Recommendation Report for Planning Permission for Works or Extension to a Dwelling

REF NO: R/13/25/HH

LOCATION: 26 Evelyn Avenue
Rustington
BN16 2EJ

PROPOSAL: Single storey front porch and rear extension. Conversion of loft to habitable use including 1 No. rear Juliet Balcony. Proposed solar panels array to south elevation. Alterations to side fenestration.

Drawing No
240014/ 03

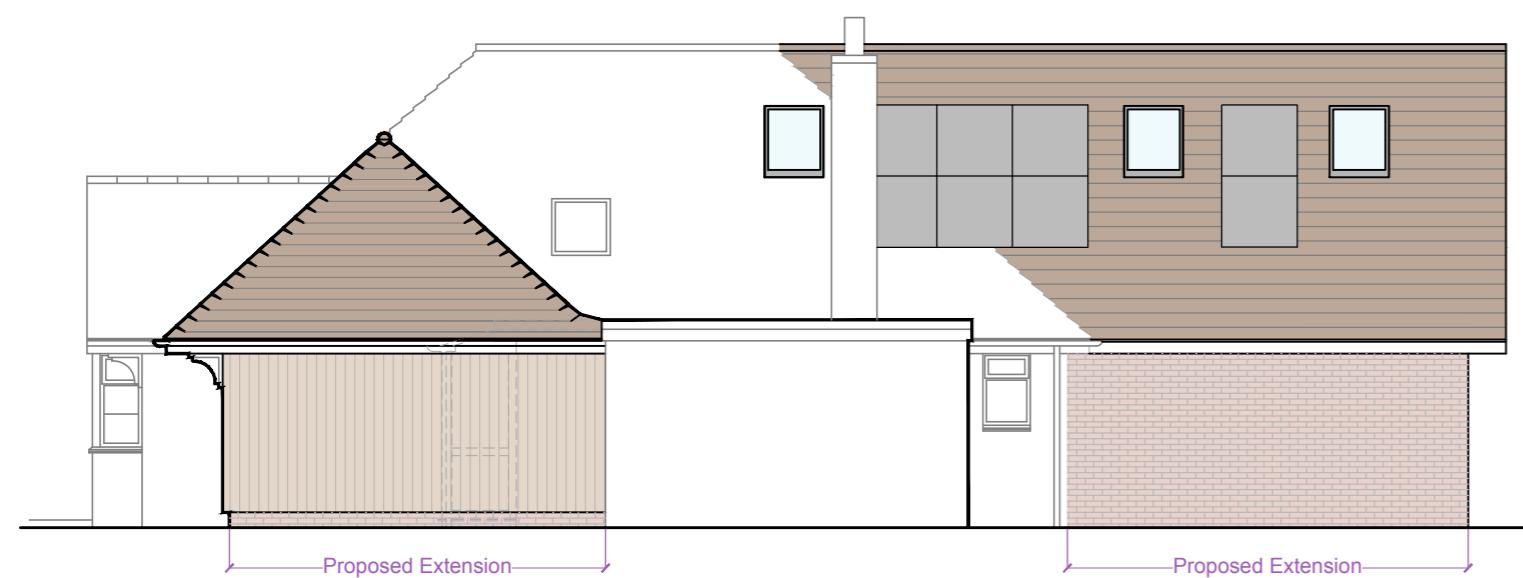
The property is a detached bungalow with an existing single storey addition to the south of the property. The additions include a rear extension and porch; the latter would be visible from the public realm. The rear extension would extend 5.3m from the rear elevation across the width of the existing rear elevation. The extension would have a pitched roof, matching the height of the existing roof, with a gable end. The roof space of the extension would be habitable space, served by four rooflights. As the addition would

not be set down from the ridge height, the extension would not be visually subservient to the main dwelling, in partial conflict with policy D DM4 of the Arun Local Plan. However, the extension is integrated into the existing dwelling, and the use of facing brickwork and concrete tiles reflects the materials of the existing dwelling.

The proposed porch would extend from the south elevation, and adjoin the existing flat roofed addition on this elevation. The porch would mirror the projection on the north elevation which houses the attached garage, and would have the same hipped roof form. The porch would be finished with concrete roof tiles to match the existing, and timber effect cladding, which will be similar to the material currently used on the gable end to the front of the property. The porch would not harm the character or visual amenity of the property or its vicinity in accordance with policy D DM1 of the Arun Local Plan.

The proposed fenestration would be sited to the rear elevation at both ground floor and first floor levels. There is currently no fenestration present at first floor level, however, there would remain a distance of 14m to the rear boundary, and the neighbour to the rear would not be adversely affected by overbearing, overshadowing or overlooking effects. Five rooflights are proposed within the side roofslopes of the host dwelling, serving the loft accommodation. The proposed rooflights are set at a high level within the roof slope and will not enable views of neighbouring properties. A condition has been added to ensure that the rooflights are positioned no lower than 1.7m above finished first floor level. The rooflights will not result in overlooking effects. The proposed alterations to the ground floor fenestration would be small in scale and would not result in any additional overlooking.

- 3 The materials and finishes of the external walls and roof of the rear extension and the roof of the porch hereby permitted shall match in colour and texture those of the existing building.

- 4 The rooflights within the roof of the rear extension on the north and south elevations of the building shall be positioned no lower than 1.7m above finished floor level. This arrangement shall be permanently retained thereafter.

240014/ 02

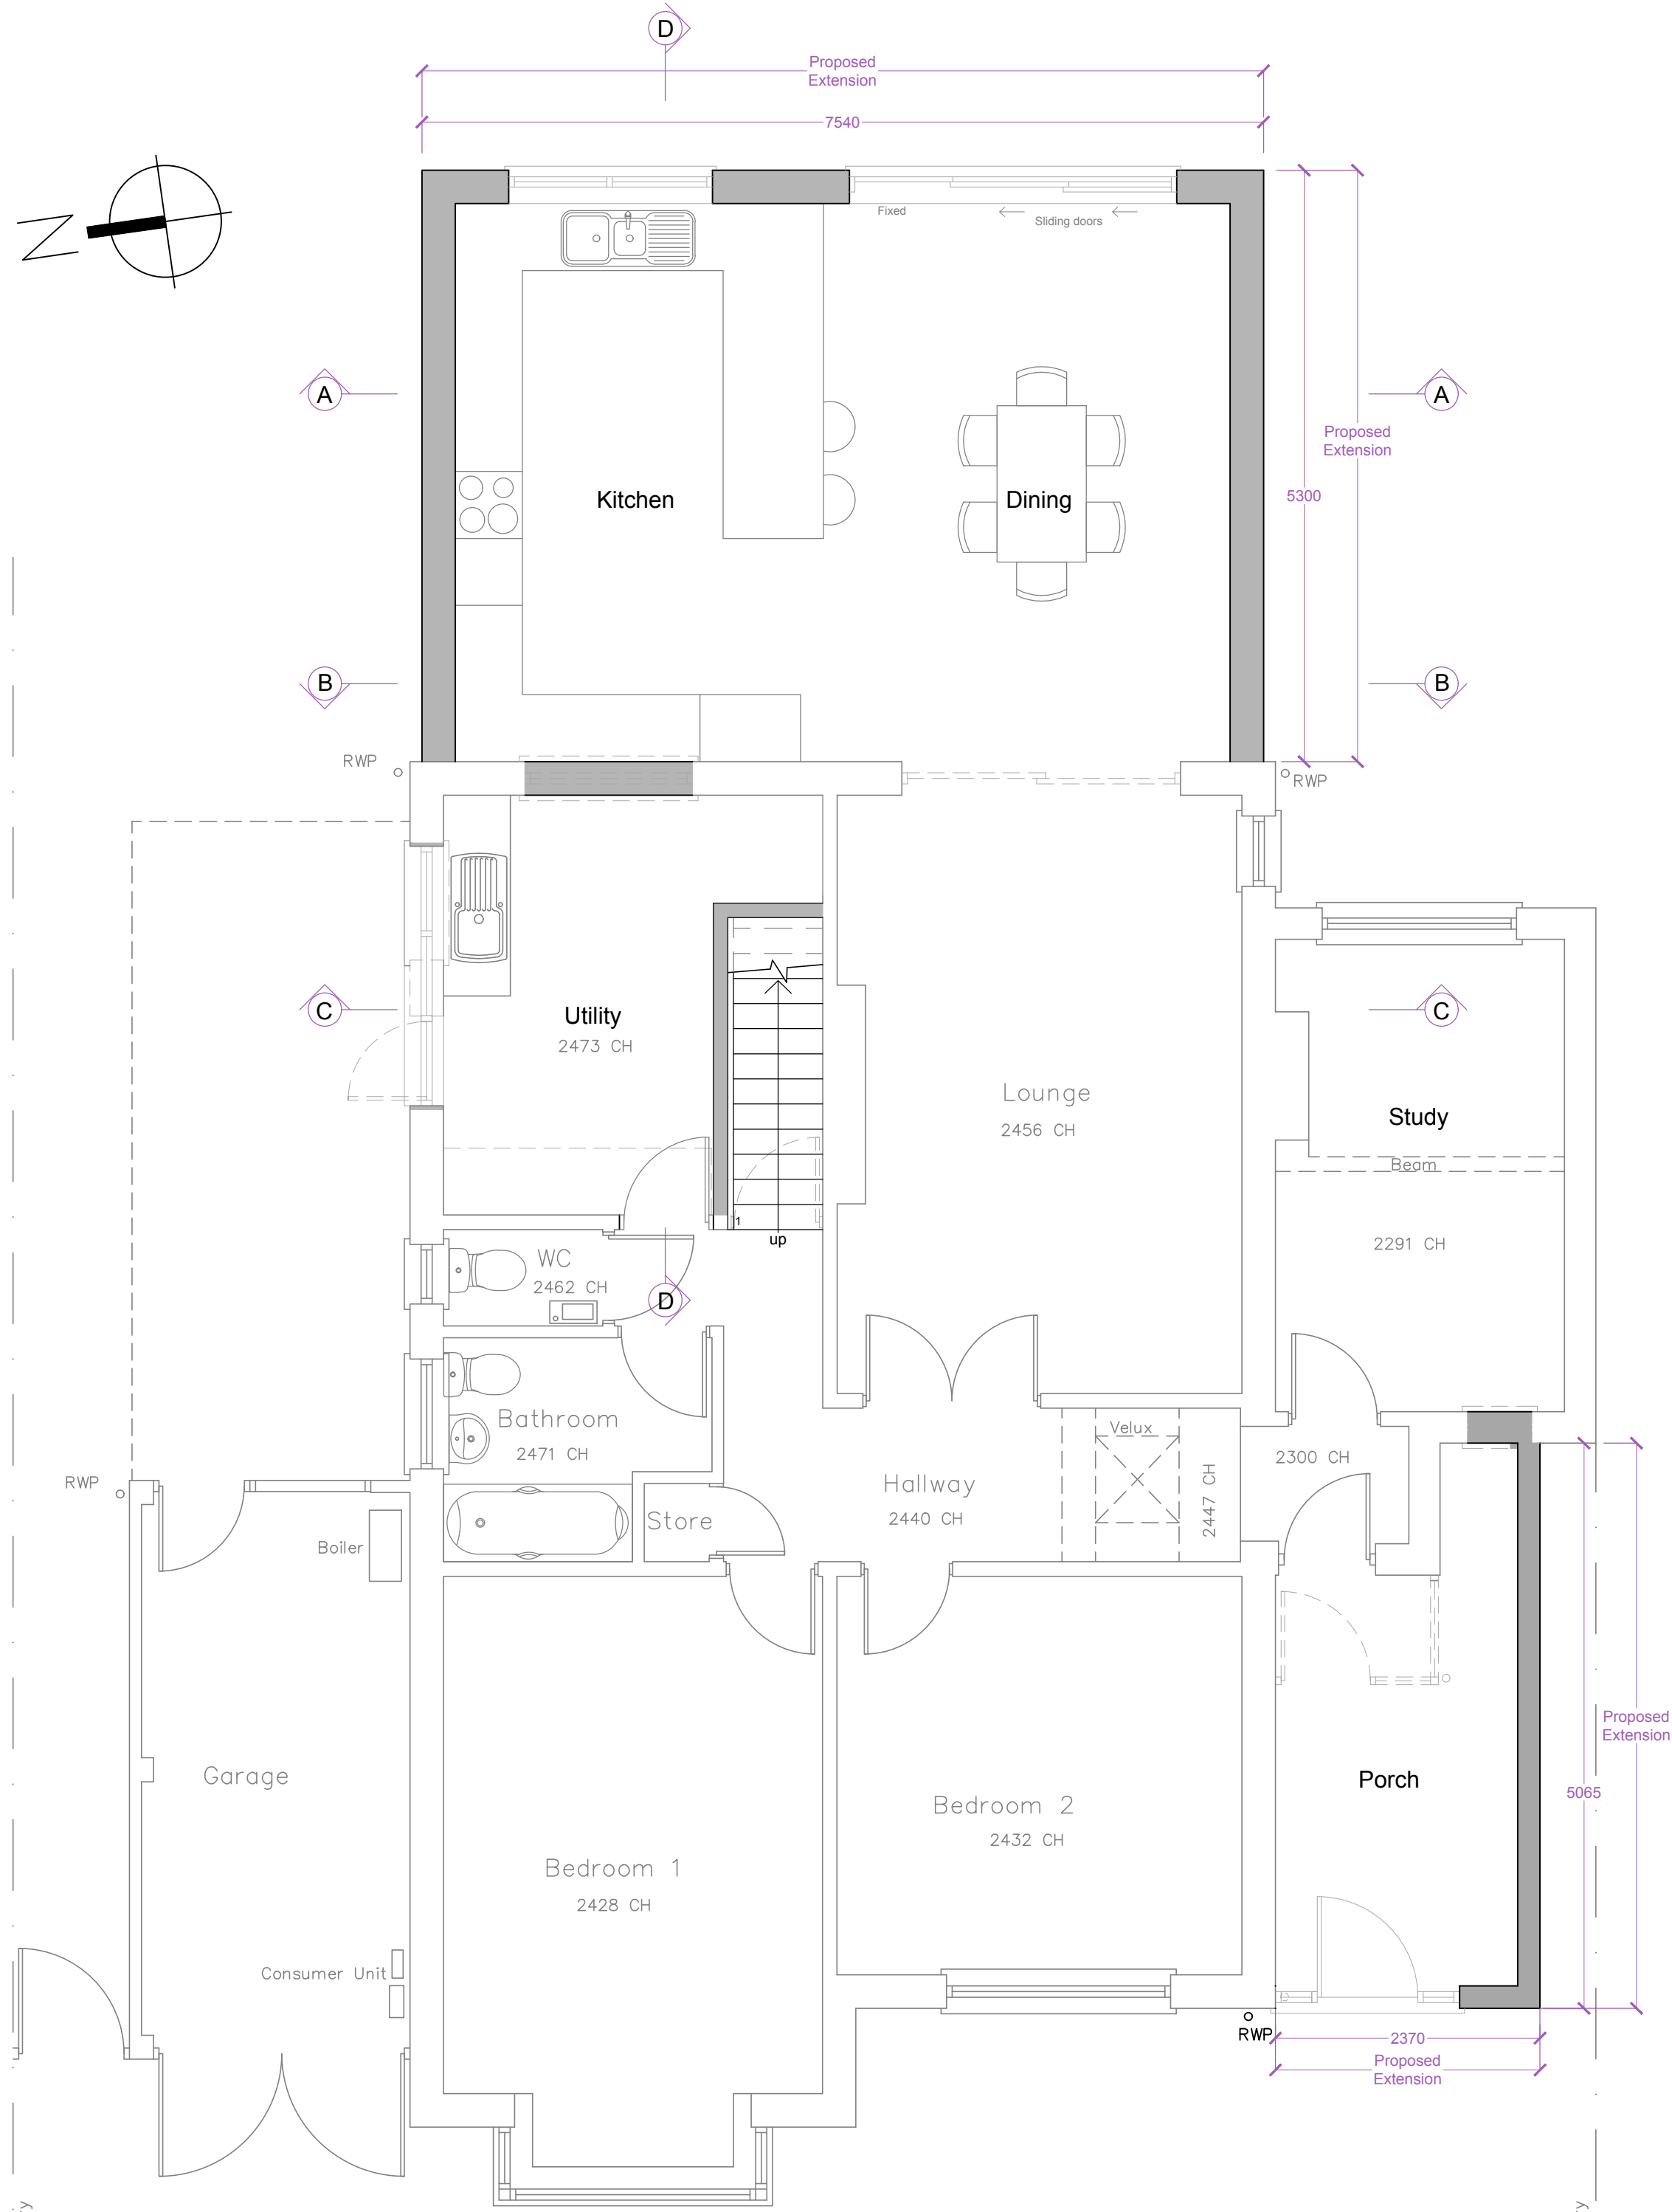
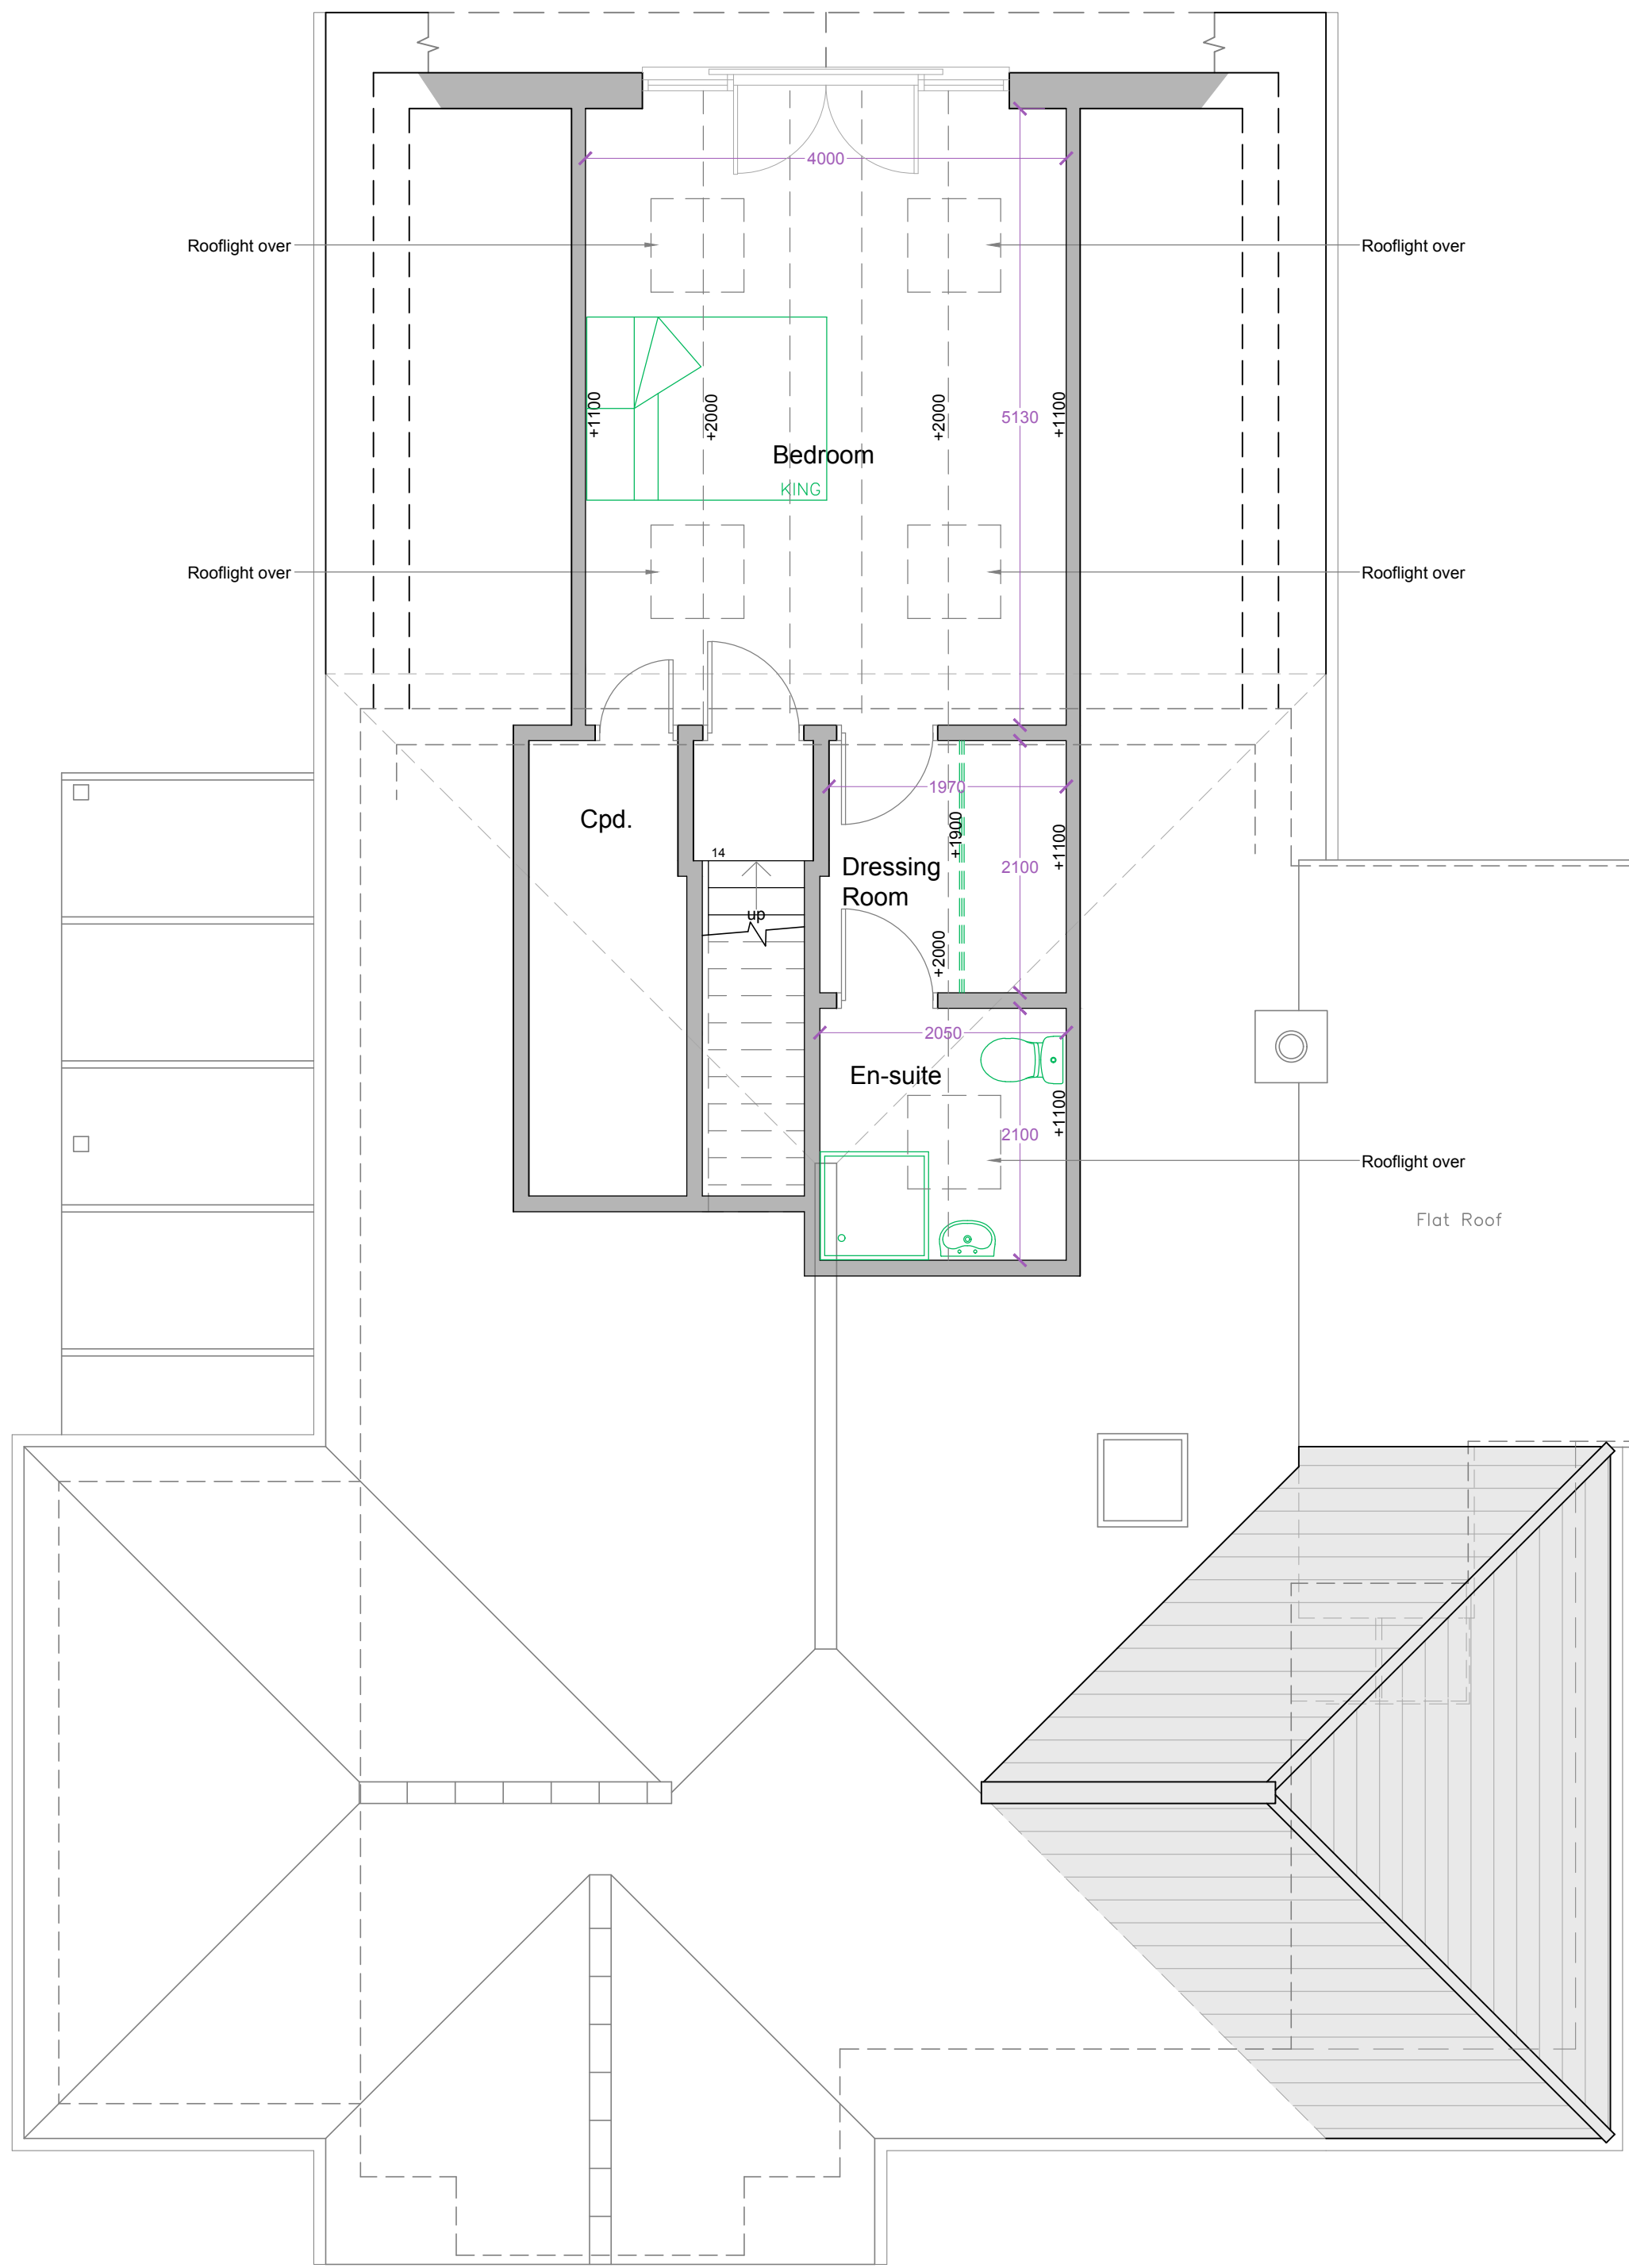
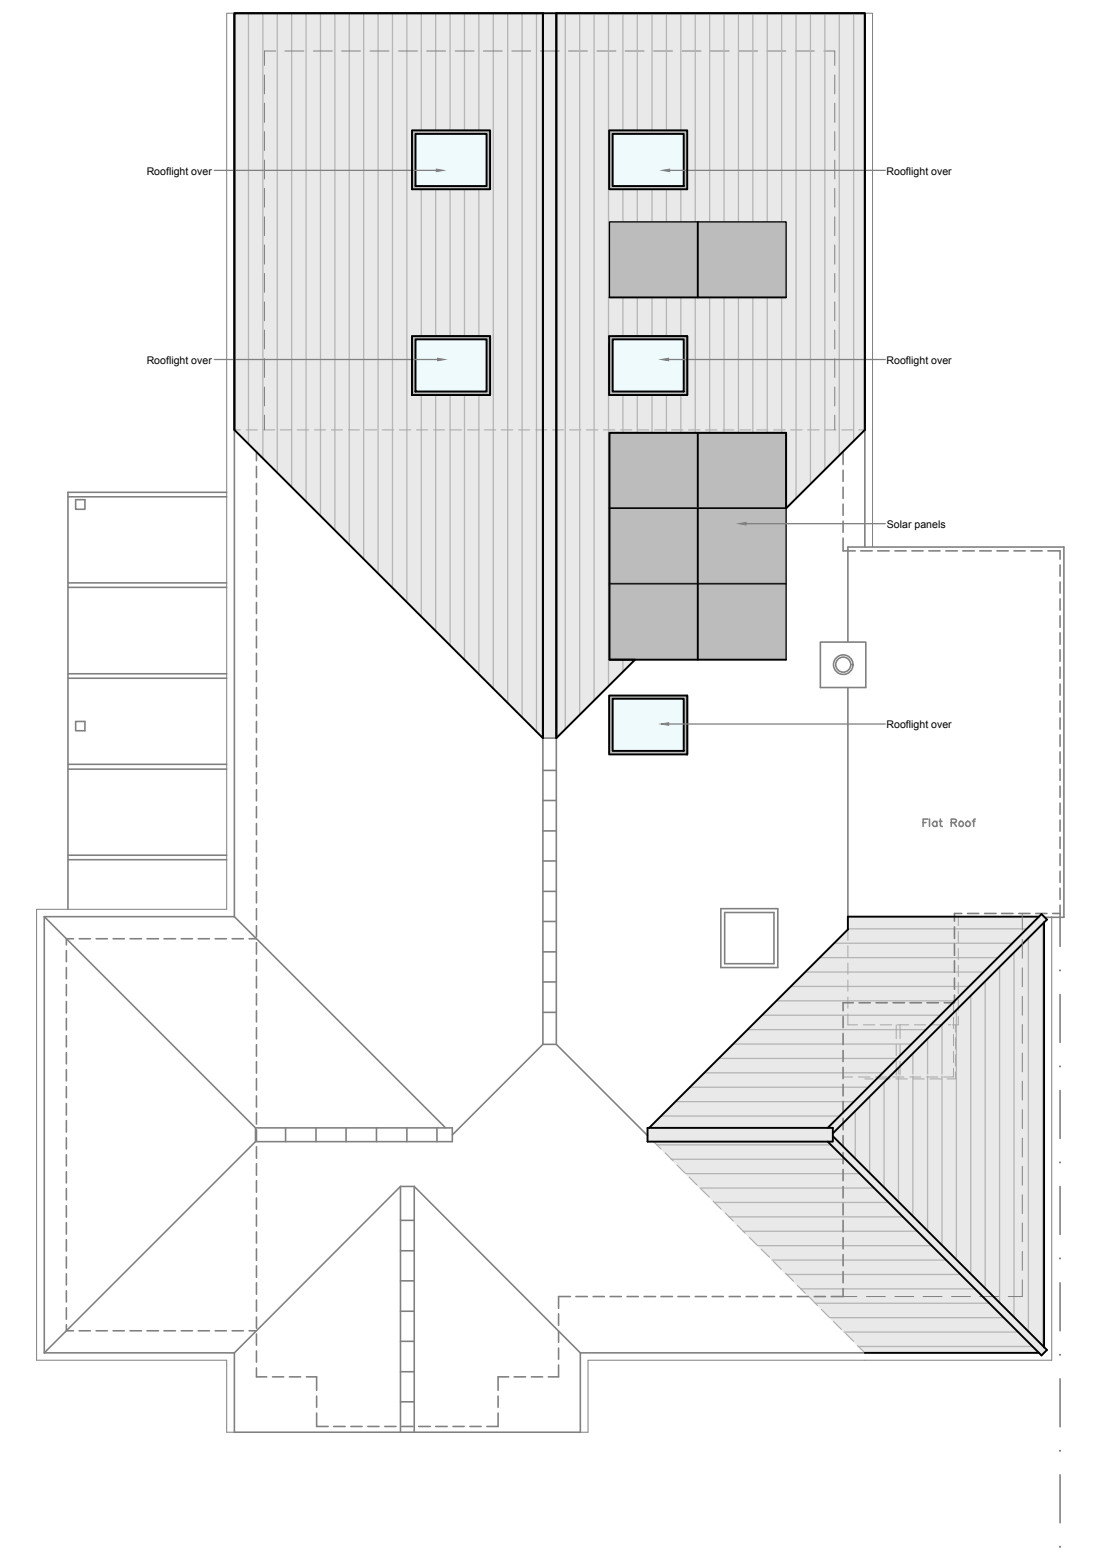
The site has neighbouring properties to the north, south and rear. The proposed rear extension would extend beyond the rear elevations of both the neighbours to the north and south. The extension would not extend significantly beyond the rear elevation of the property to the south, and the extension would not intersect a 45 or 60 degree line taken from the nearest rear window. The extension beyond the rear elevation of the property to the north is more substantial, and the impact of the extension is increased by the relationship between the properties, where the neighbouring sits at an angle with the rear elevation facing towards the site. The extension would therefore intersect 45 and 60 degree lines taken from the rear windows of the property to the north, and there would be some impact on the amenity of this neighbour. However, there remains a significant separation distance between the extension and the northern boundary, and the impact on the extension would not be so significant as to justify the refusal of planning permission in this regard.
